DRAINAGE LETTER

LOT 11, ROLLING THUNDER BUSINESS PARK

County File No.: PPR-21-24

SUBJECT: Drainage Letter
Lot 11 Rolling Thunder Business Park

Scale 1" = 20'  
Contour Interval: 1'

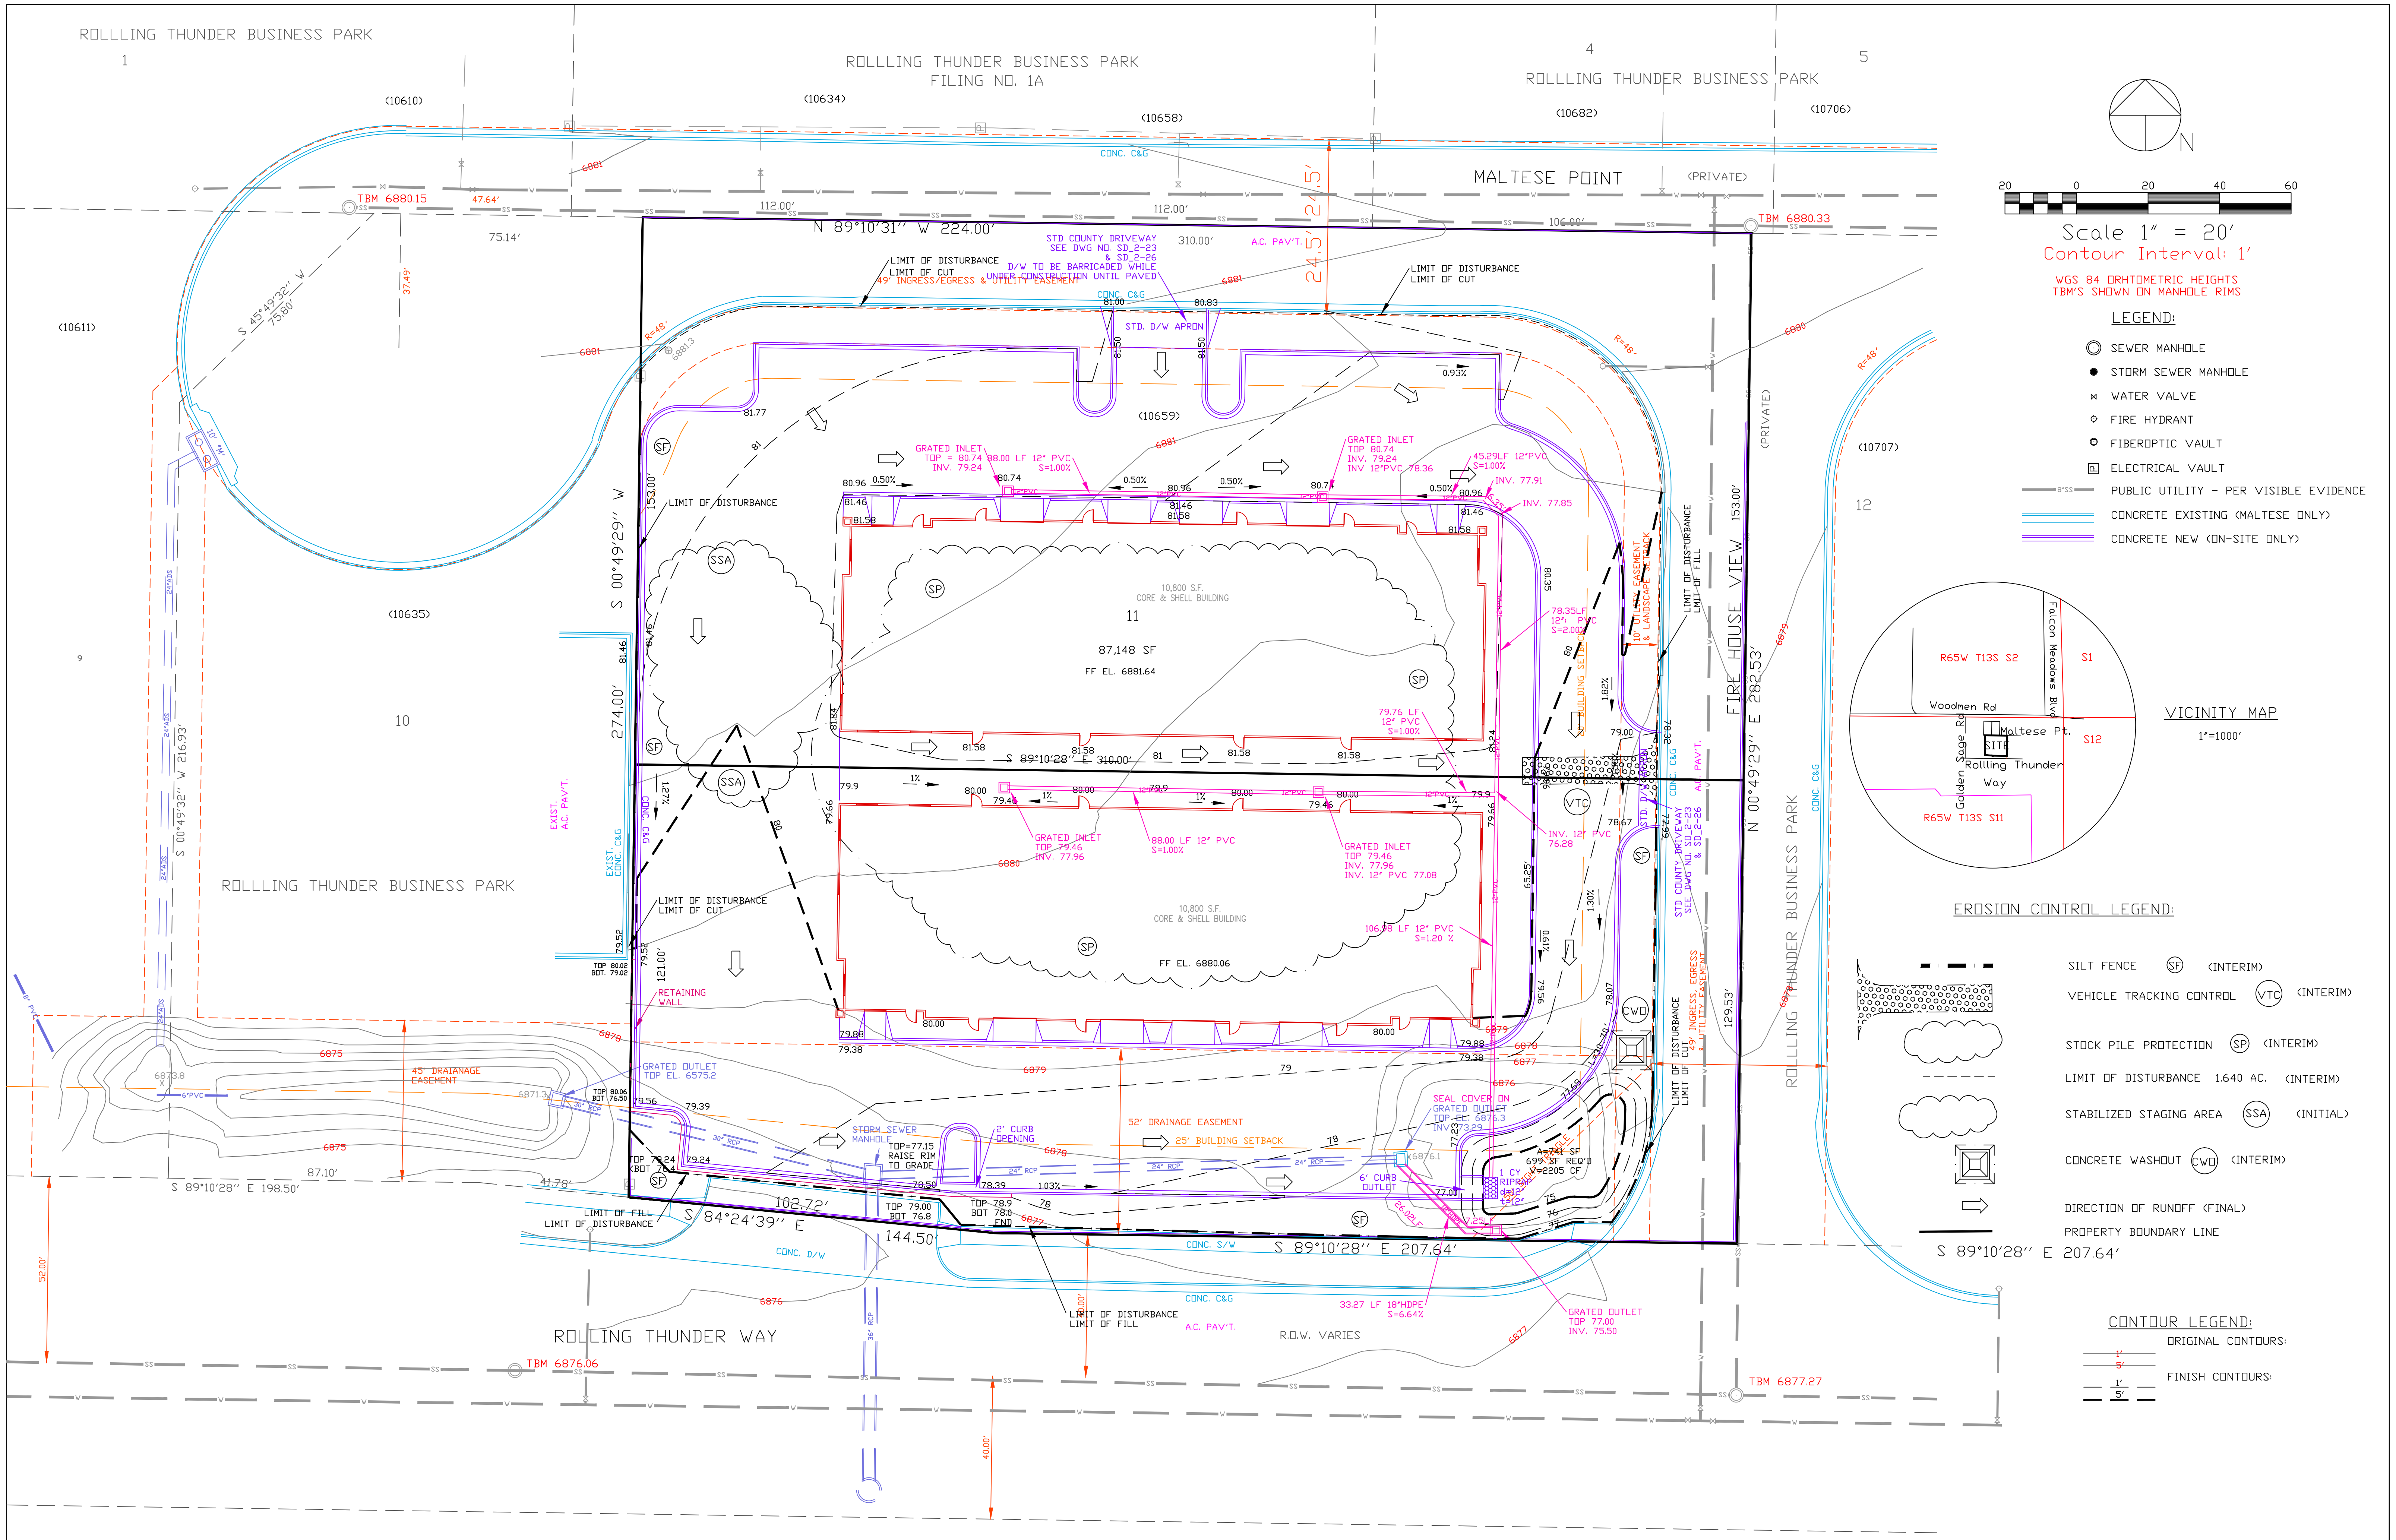
The proposed storm sewer north of the northern building was removed on the plans

Silt fence is proposed, this Site is not part of the Airport

using silt
fence at
the site
